KITTITAS COUNTY DEPARTMENT OF PUBLIC WORKS

MEMORANDUM

TO: Jeff Watson, Community Development Services
FROM: Christina Wollman, Planner II *CW*
DATE: June 29, 2010
SUBJECT: Steinman BL-10-00024

SEC 13 TOWNSHIP 19 NORTH RANGE 17 EAST W.M.

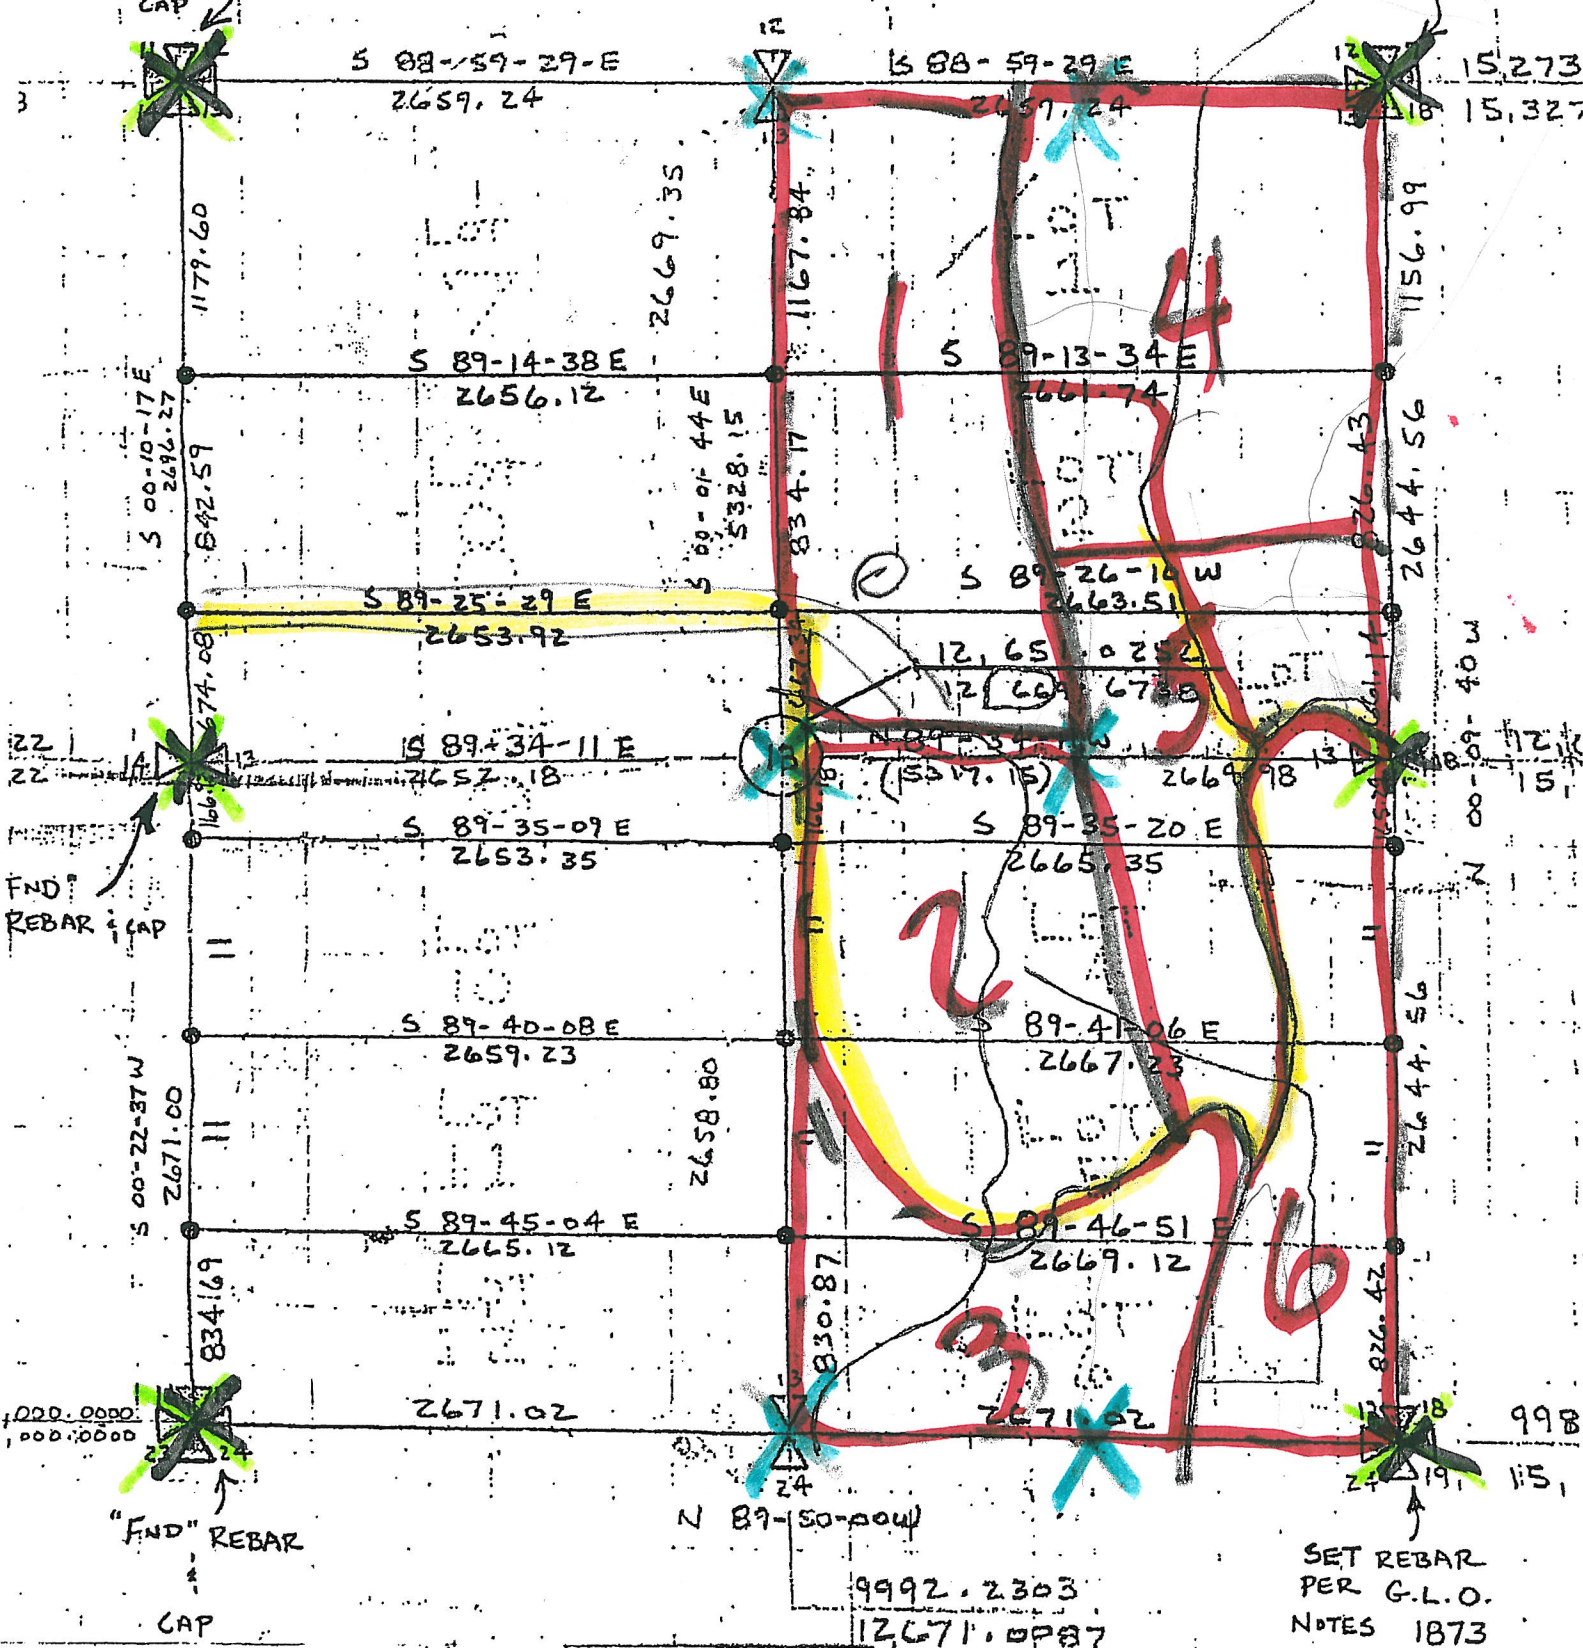
1. The proposed access with appropriate easement(s) shall be shown and shall conform to applicable Kittitas County Road Standards.
2. A revised legal description that describes the final configuration of the subject property shall be required.
